Question

Kippure Lodge and Holiday Village,
Kippure Estate, Manor Kilbride,
Blessington, County Wicklow.

Wicklow County Council

EX53/2024

Structure 02

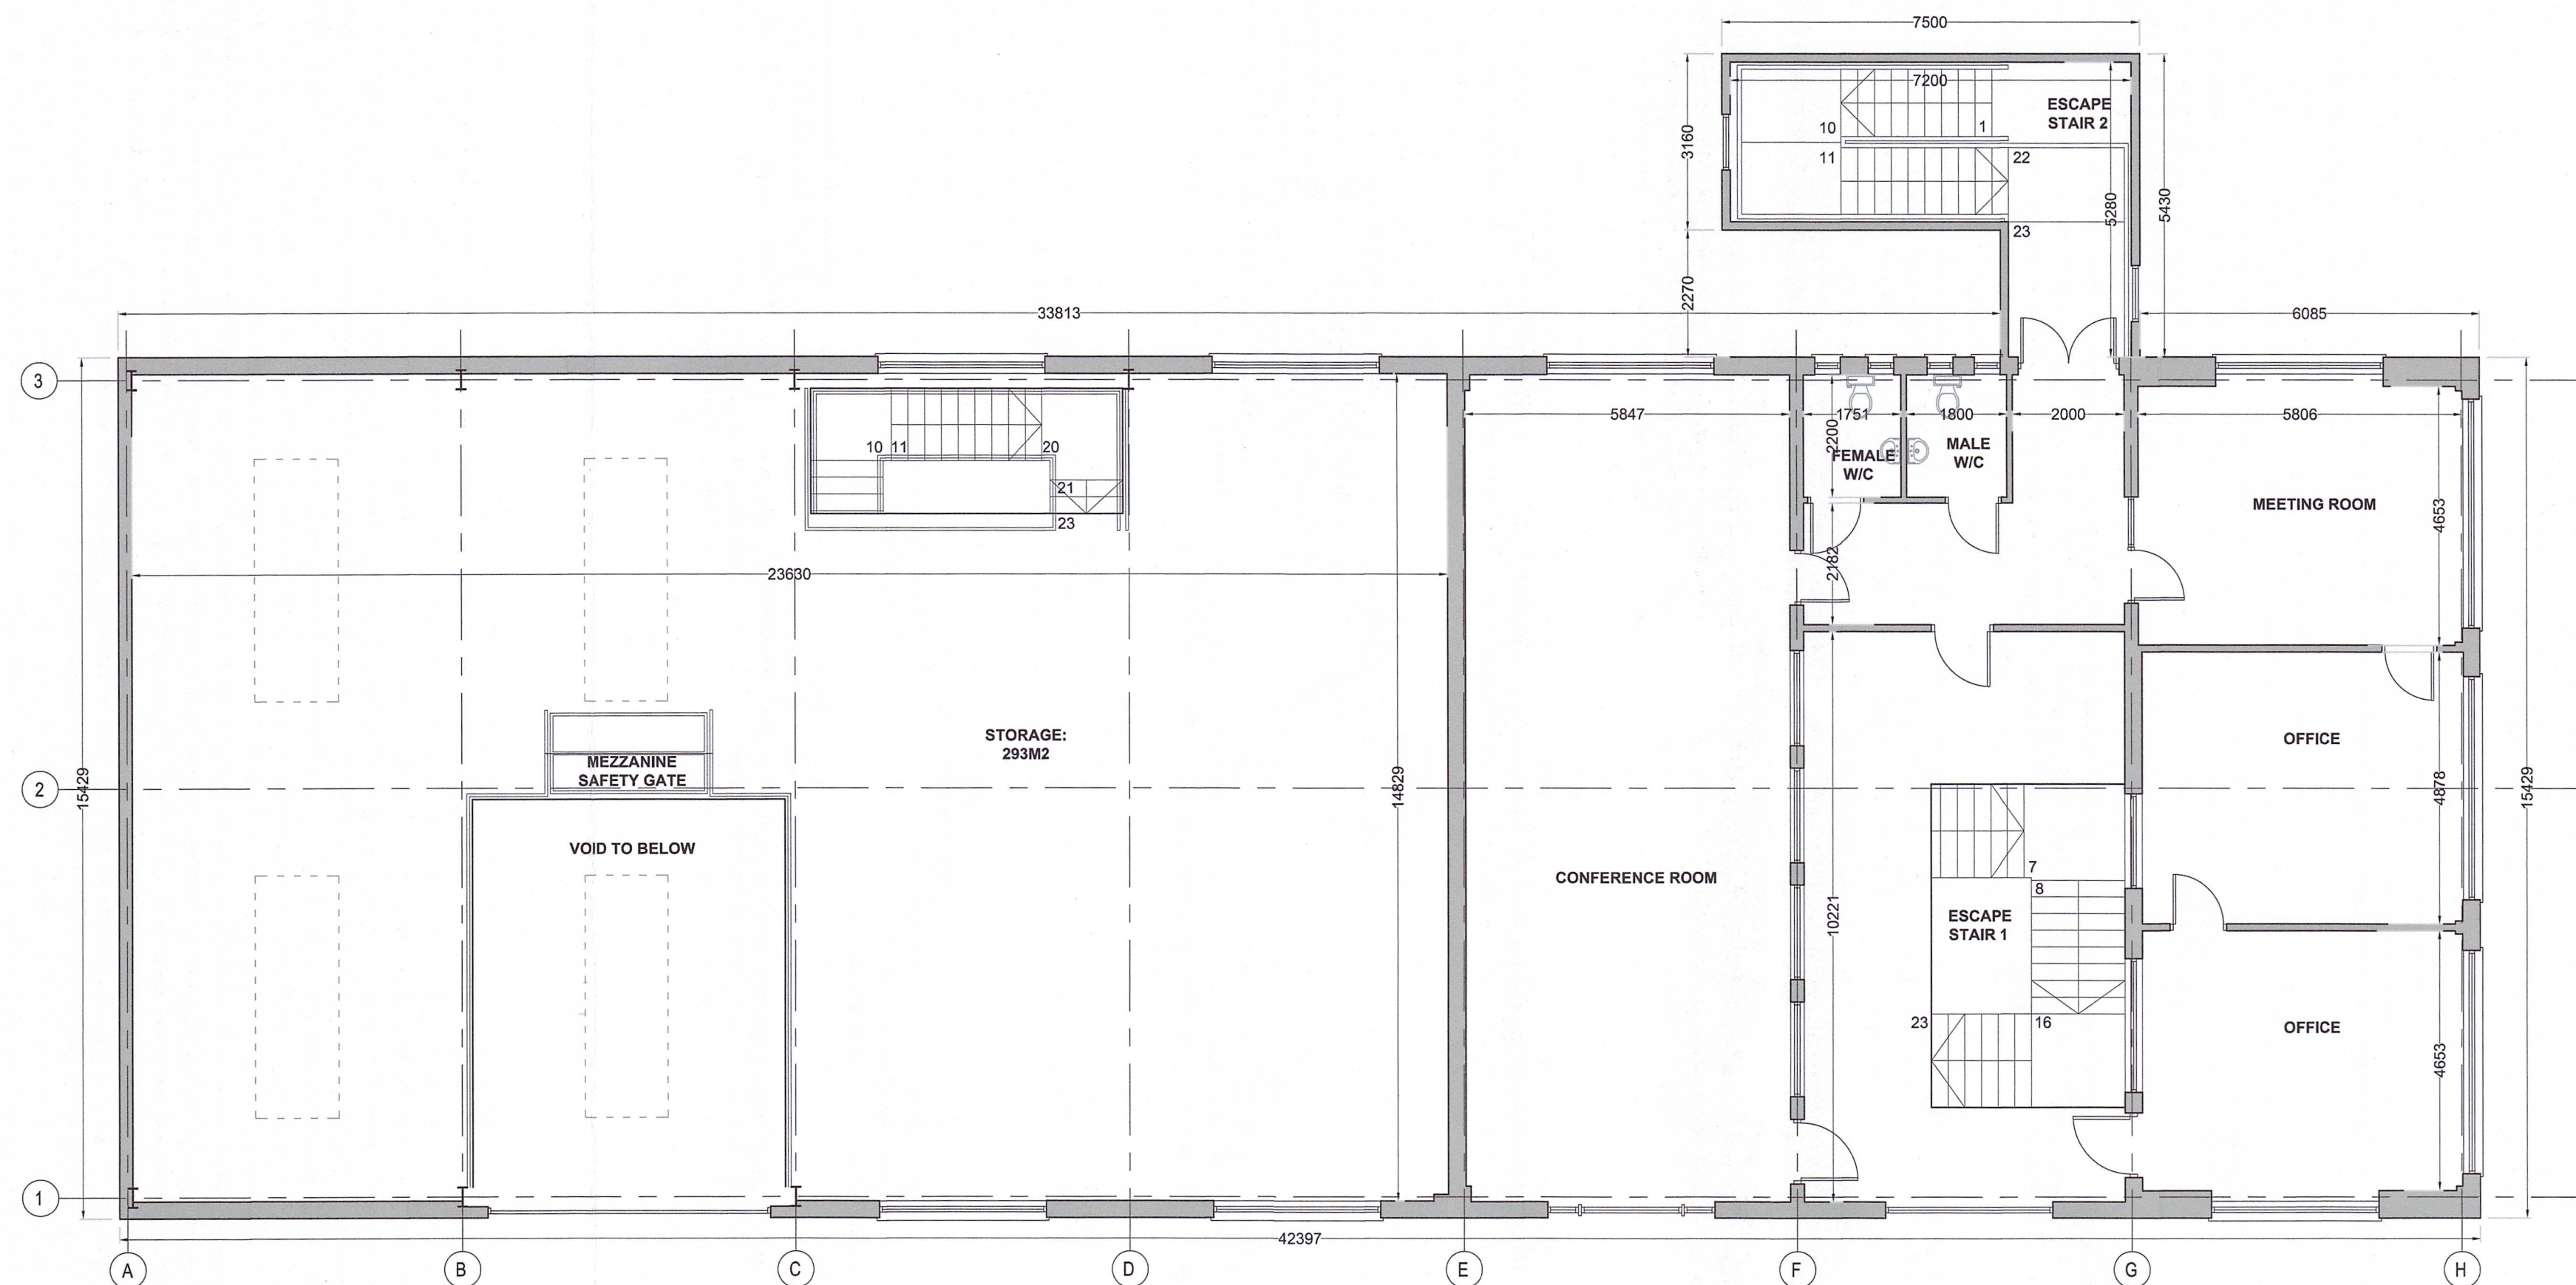
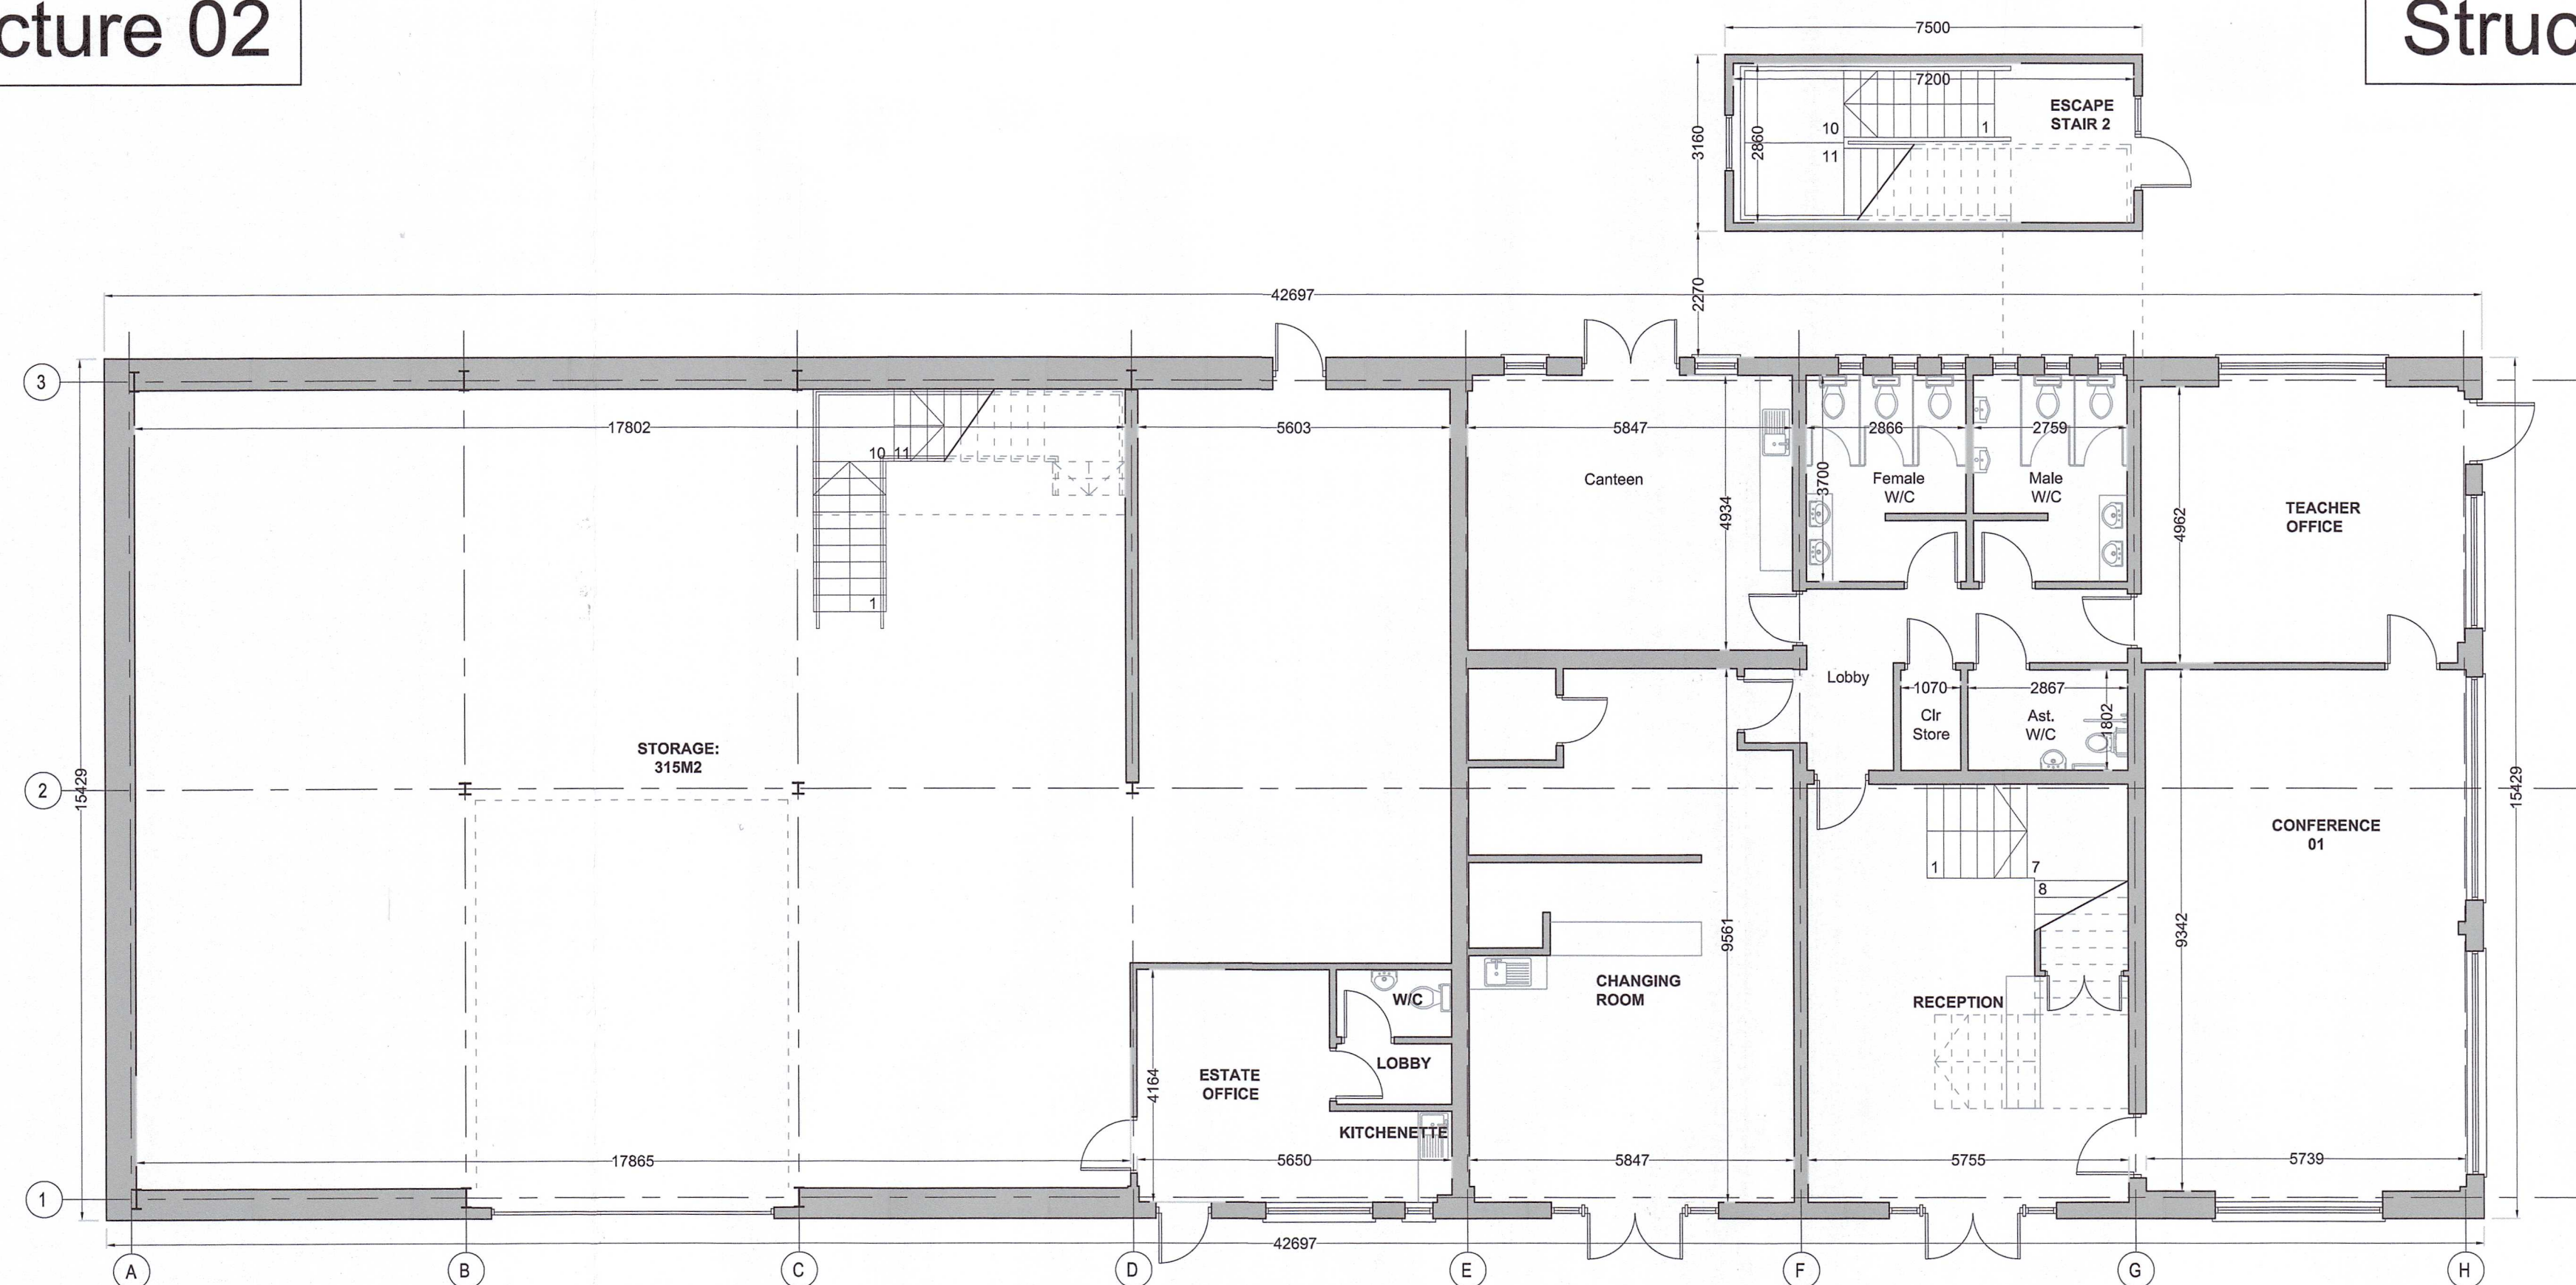
It would appear from aerial photography that this structure and the adjacent structure no. 6 were constructed between January 2020 and March 2022. The structure come within the meaning of works and would therefore come within the meaning of development as provided for in Section 3(1) of the PDA. Class 9 of Part 3 -Exempted Development - Rural of Schedule 2 provides an exemption for any store, barn, shed, glass house or other structure, having a gross floor area (GFA) not exceeding 300sqm. The structure has a GFA of 660sqm.

- From an inspection the structure is in use for the storage of building materials and would not appear to be in use for agriculture, as defined under Section 2 of the PDA.
- Taking into account the overall floor area of this structure and Structure no. 6 (1,134sqm) it would exceed the aggregate 900sqm limitation.
- The structure is in excess of 10m from the public road.
- The structure is not within 100m of any house.
- Metal sheeting on the structure is painted.

The structure would not come within the provisions of Class 9 and therefore is not exempted development.

It would appear from aerial photography that this structure and the adjacent structure no. 2 were constructed between January 2020 and March 2022. The structure comes within the meaning of works and would therefore come within the meaning of development as provided for in Section 3(1) of the PDA.

Class 9 of Part 3 of Schedule 2 provides an exemption for any store, barn, shed, glass house or other structure, having a gross floor area (GFA) not exceeding 300sqm. The structure has a GFA of 500sqm (excluding the external stairwell).

- This structure is indicated to have been in agricultural use however no evidence is provided.

- Taking into account the overall floor area of this structure and Structure no. 2 (1,134sqm) it would exceed the aggregate 900sqm limitation.
- The structure is in excess of 10m from the public road.
- The structure is not within 100m of any house.
- Metal sheeting on the structure is painted.

Structure 03

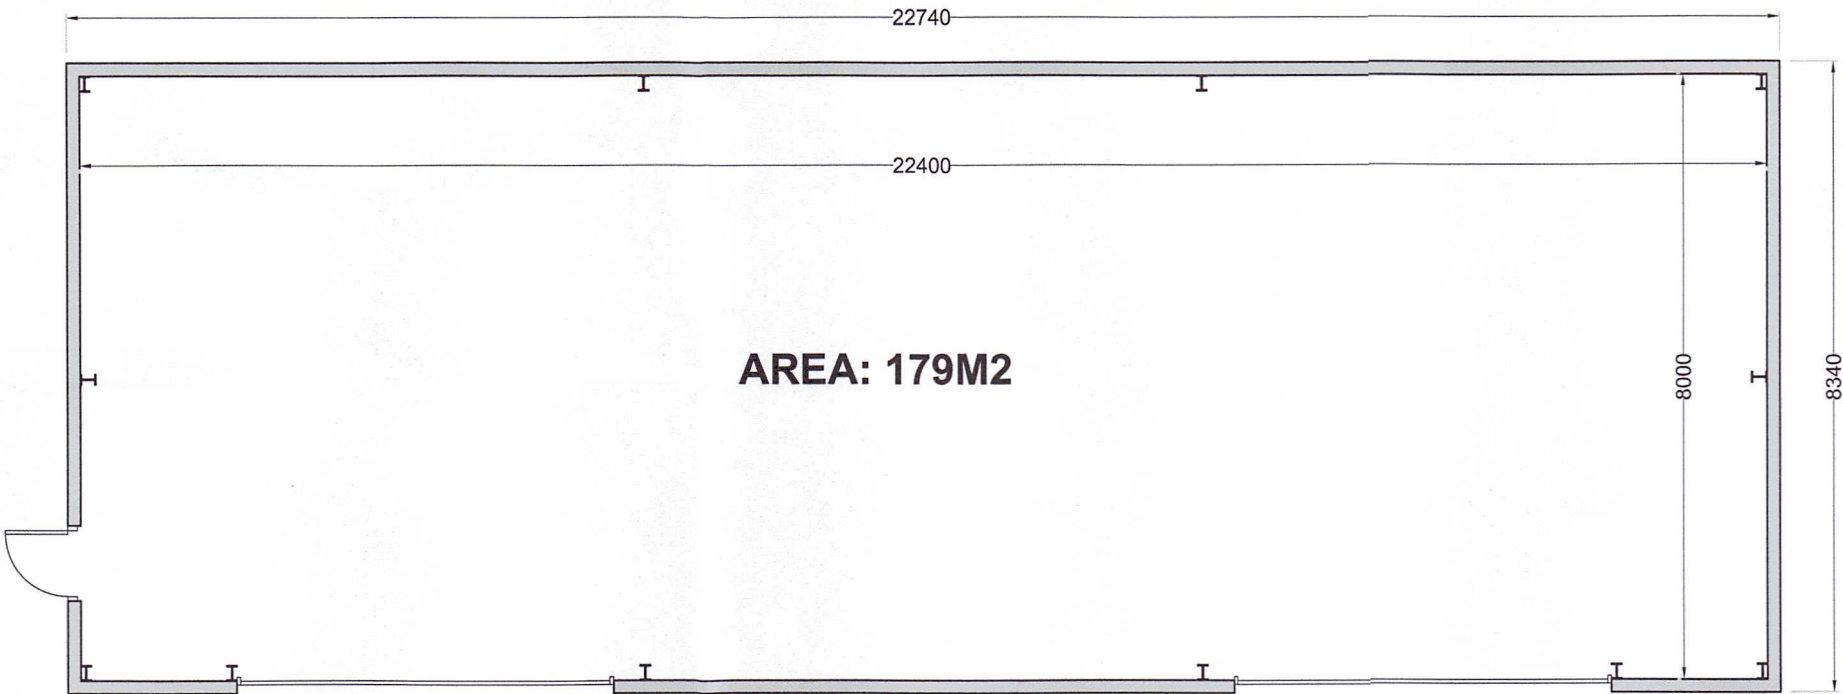
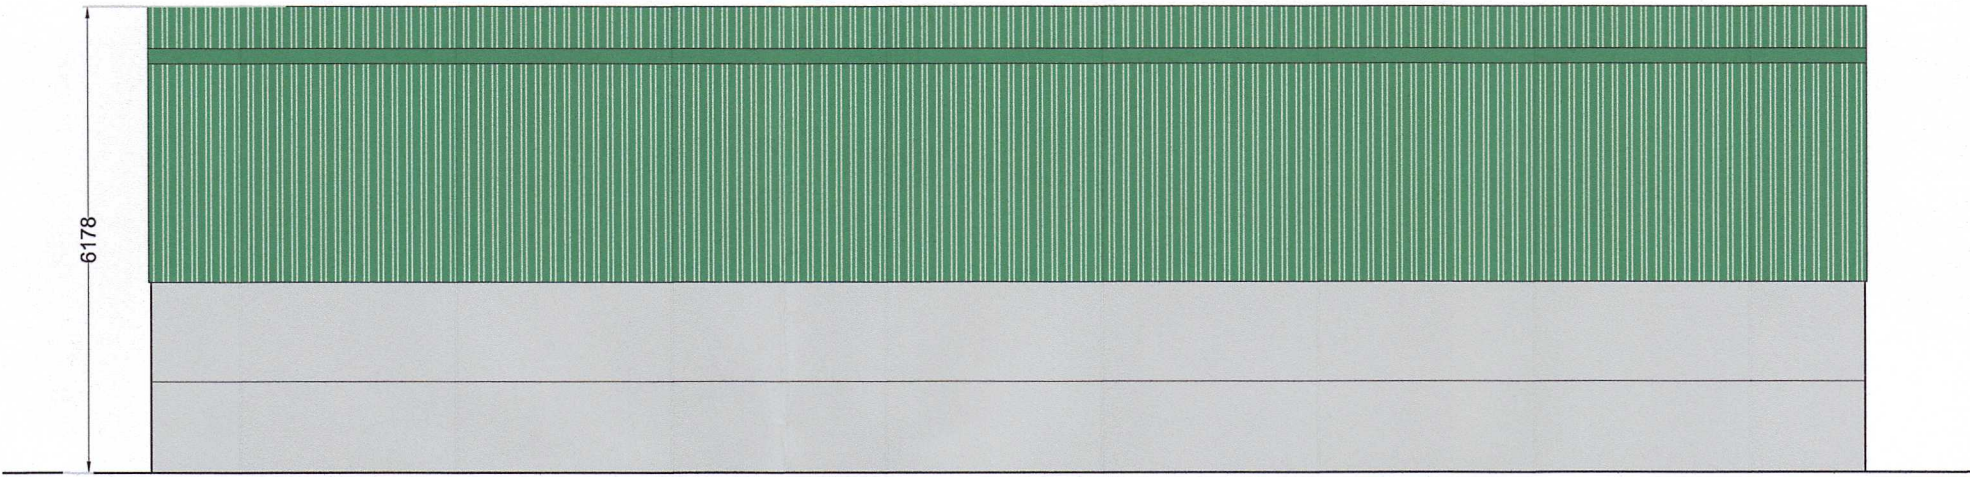
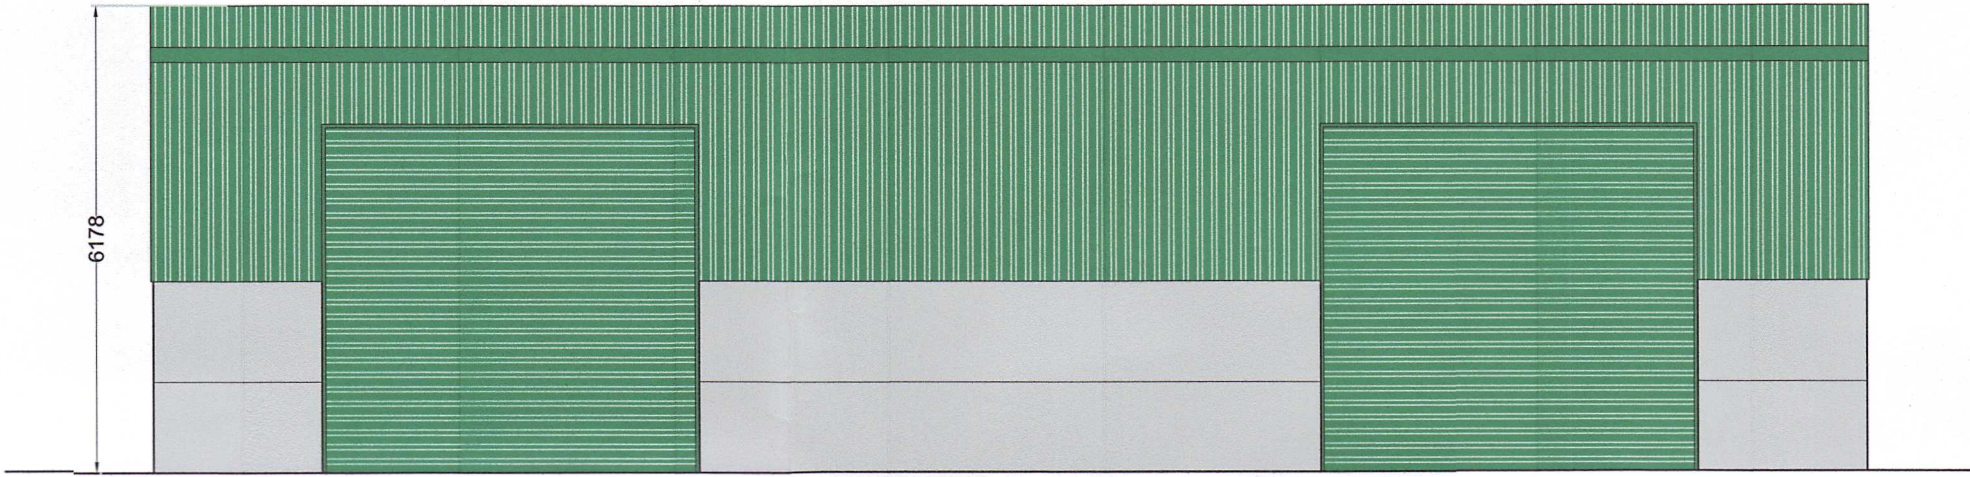
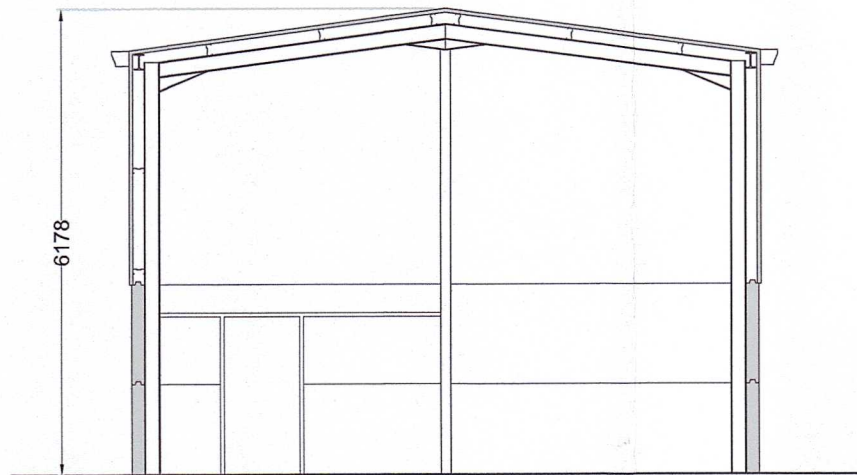
It would appear from aerial photography that this structure was constructed after March 2022. The structure comes within the meaning of works and would therefore come within the meaning of development as provided for in Section 3(1) of the PDA.

Class 9 of Part 3 of Schedule 2 provides an exemption for any store, barn, shed, glass house or other structure, having a gross floor area (GFA) not exceeding 300sqm. The structure has a GFA of 179sqm.

- No evidence is provided to confirm the structures use and there appears to be some storage in relation to the construction works on site.
- Structure no. 2 and 6 were completed prior to this structure and have an overall area of 1,134 sqm and would exceed the aggregate 900sqm limitation.
- The structure is in excess of 10m from the public road.
- The structure is not within 100m of any house.
- Metal sheeting on the structure is painted.

The structure would not come within the provisions of Class 9 and therefore is not exempted development.
